From: [Dave Anderson](#)
To: [Evan Maxim](#)
Cc: [Gordon Ahalt \(gjahalt@gmail.com\)](#); [anderson9200@comcast.net](#); [londonimplant@gmail.com](#); [robertroyalgraham@gmail.com](#); [robin@sammgroup.com](#); [vduchaine@comcast.net](#); "Rick Duchaine"
Subject: MI Treehouse SEPA Review 5637 East Mercer Way, Mercer Island, WA 98040
Date: Sunday, December 1, 2019 4:06:59 PM

From: [Dave Anderson](#)
To: [Evan Maxim](#); [gjahalt@gmail.com](#)
Cc: [anderson9200@comcast.net](#); [londonimplant@gmail.com](#); [robertroyalgraham@gmail.com](#); [robin@sammgroup.com](#); [vduchaine@comcast.net](#); "Rick Duchaine"; [Bio Park](#)
Subject: RE: CAO15-001; SEP15-001; VAR18-002; Treehouse SEPA Review 5637 East Mercer Way, Mercer Island, WA 98040
Date: Friday, October 4, 2019 11:33:51 AM

Drawing file: November 4 2019 Materials / site plan - 2019-11-04-15-22-41.pdf

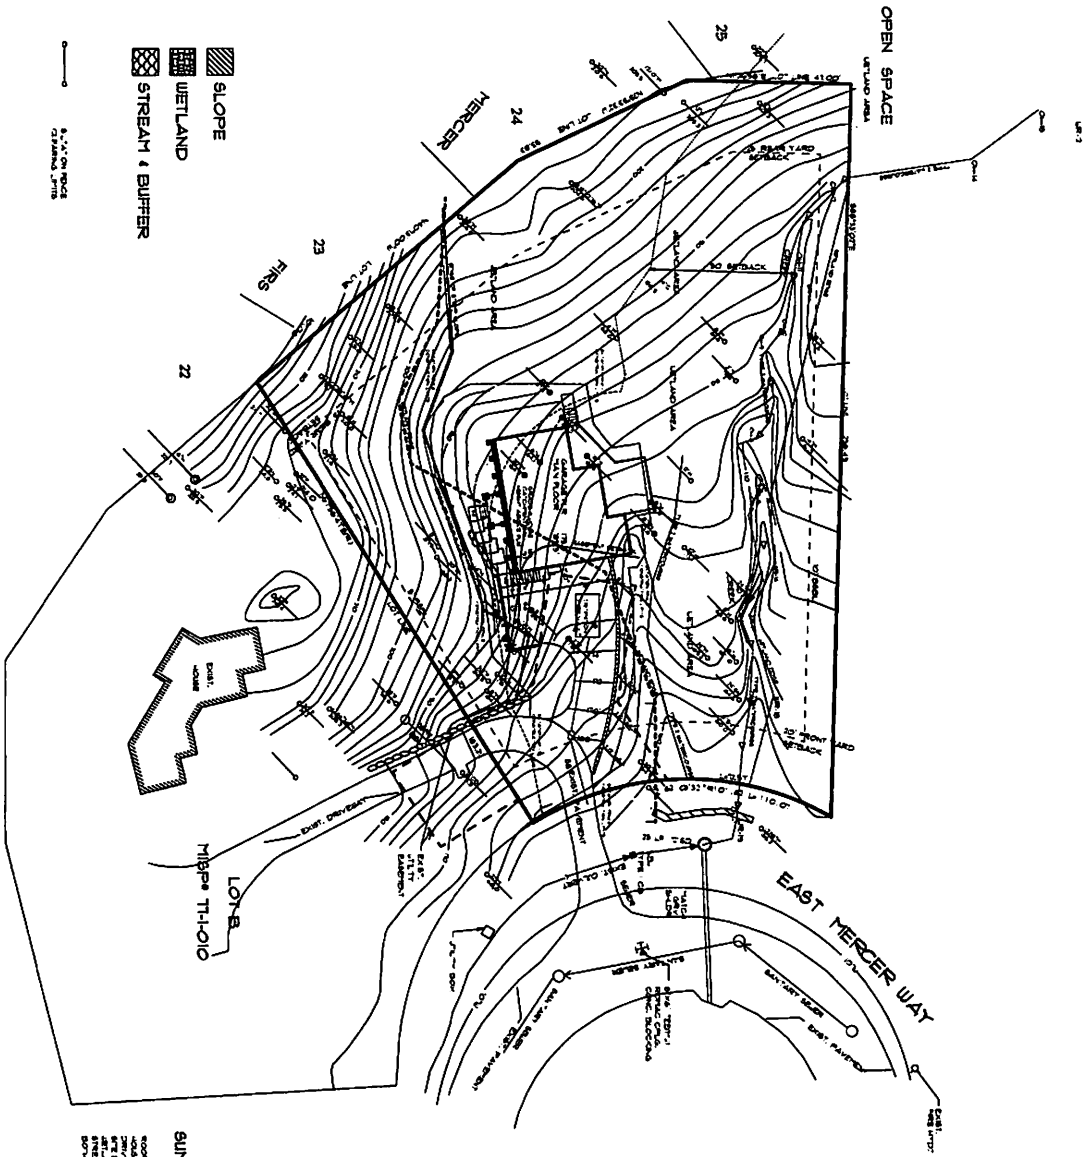
It is my understanding that the foundation drainage system including that associated with the proposed retaining wall will be approximately 10 feet below the existing wetland elevation. This is required to prevent hydraulic forces associated with the ground water from applying pressure on these walls. This will require the perched water table elevation to be lowered to below an approximate elevation of 178 feet (at least 18 inches below the garage elevation of 179.5). Much of the water intercepted by these drains would be seeping out of the wetland slope into the existing type 2 watercourse. The movement of this water through a pipe will be quicker and more efficient than this seepage. As the existing sandy soils are very wet or saturated, lowering the perched water table elevation will almost certainly impact the adjacent upland wetland areas. Given the drainage characteristics typically associated with sandy outwash soils and that these soils are currently saturated, the impact to could extend quite some distance to the west. The site plan and the associated disturbed wetland areas still do not reflect or account for these impacts that will be permanent.

Please note that the recommendations included in Section 5.6 of the geotechnical report for drainage are also not acknowledged on the site plan or in the tabulated areas of wetland disturbance. This includes a recommendation to slope the ground surface away from the proposed building at a gradient of at least 3% for a distance of at least 10' away from the building for all areas that are not paved. This would include grading and surface impacts to the existing wetland areas south and west of the building site.

Drawing file: CAO15-001 SEP15-001 VAR18-002 / site plan revised 5-8-18.pdf

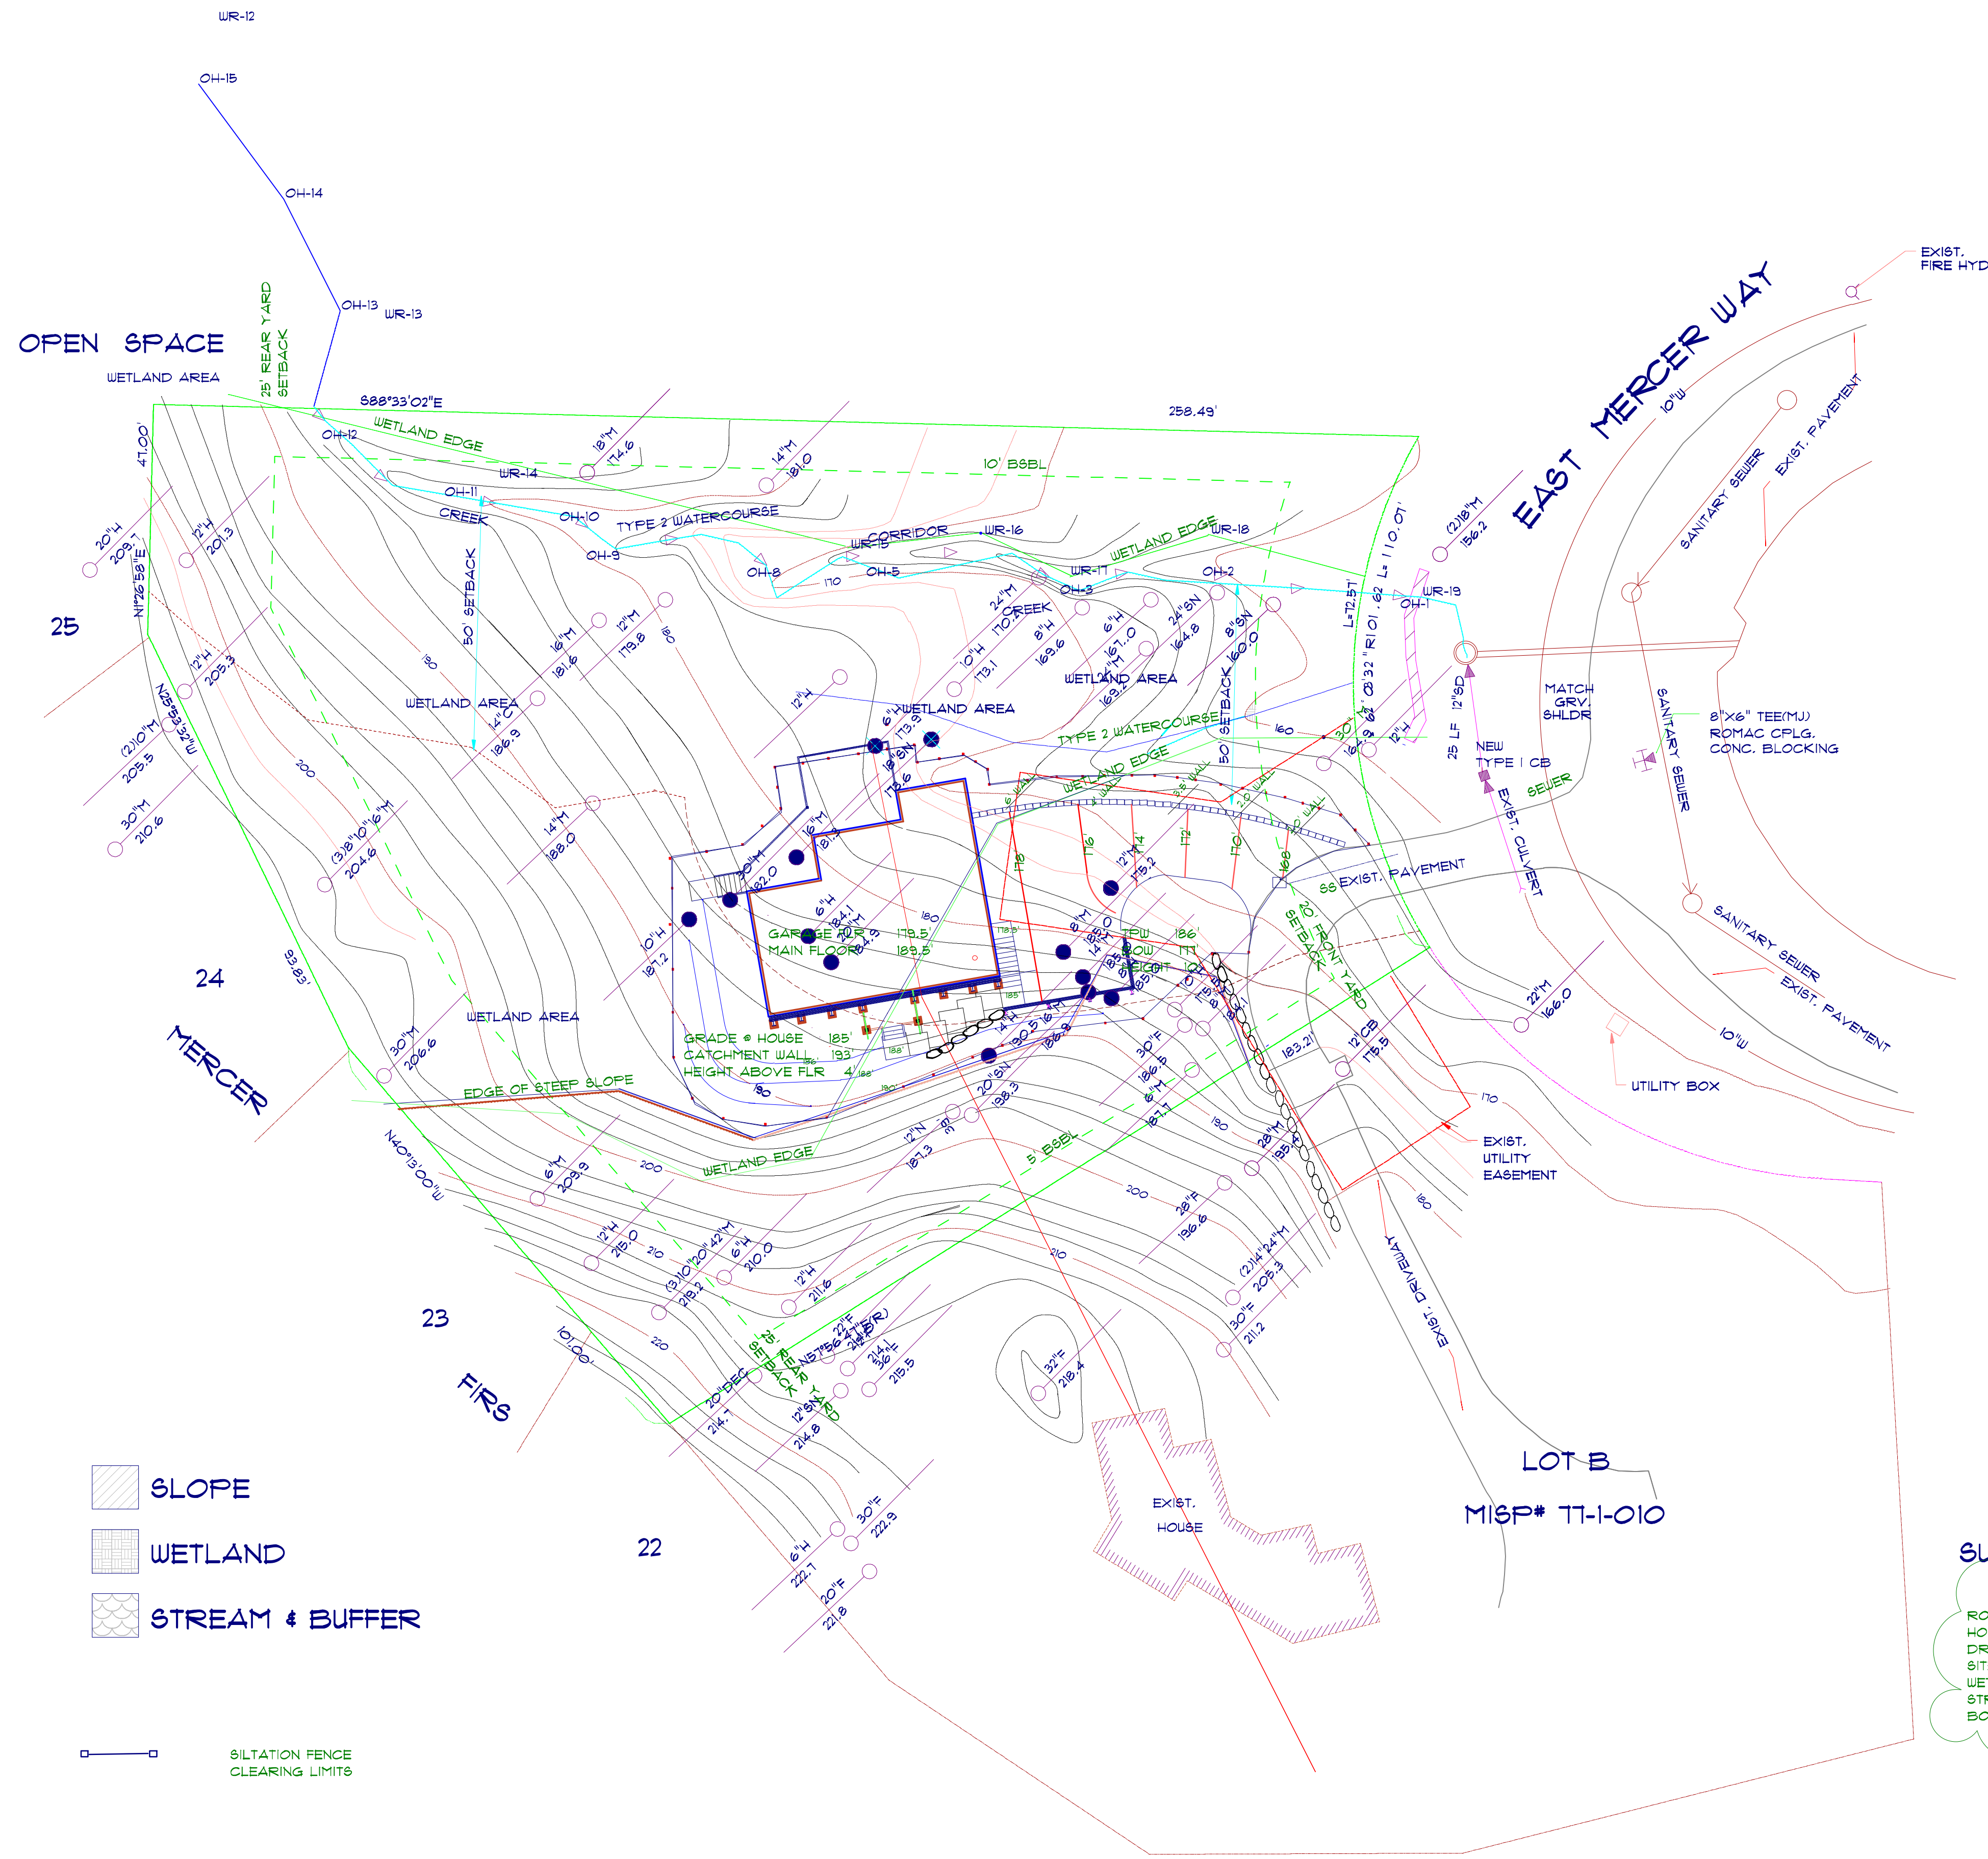
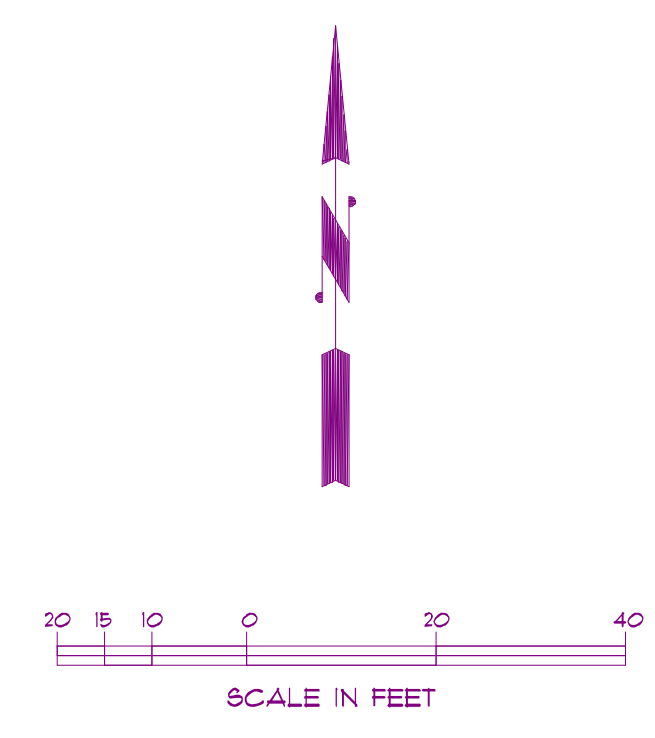
The statement that the SEPA submittal and RUE application "*materials are not entirely as detailed*" does not accurately represent what has been provided by MI Treehouse. Details aside, the revised site plan does not include any schematic drainage plan or the proposed discharge locations. The vault and any references to the proposed storm drainage system have been removed from the updated plan. There is no reference whatsoever to the retaining wall drainage, perforated drainage for the proposed detention vault, and any foundation drainage in either the plan or the SEPA checklist. The written responses in the SEPA checklist are limited to vague one-sentence responses. The proposed project is located within a wetland, within water course buffers, and in an area where there has been downstream drainage issues in the past. How can we be expected to provide any meaningful review or comment on the proposal without any information on these drainage systems?

These items have not been addressed with the SEPA. As noted on my previous e-mail correspondence, a storm water detention vault was shown schematically on the 2015 site plan but was removed from the 2018 plan. None of the plan requirement listed above were included with the SEPA. I am assuming that these will be included in the RUE submittal as listed on the Land Use Application - Plan Set Guide. Will we have an opportunity to review and comment on this submittal?
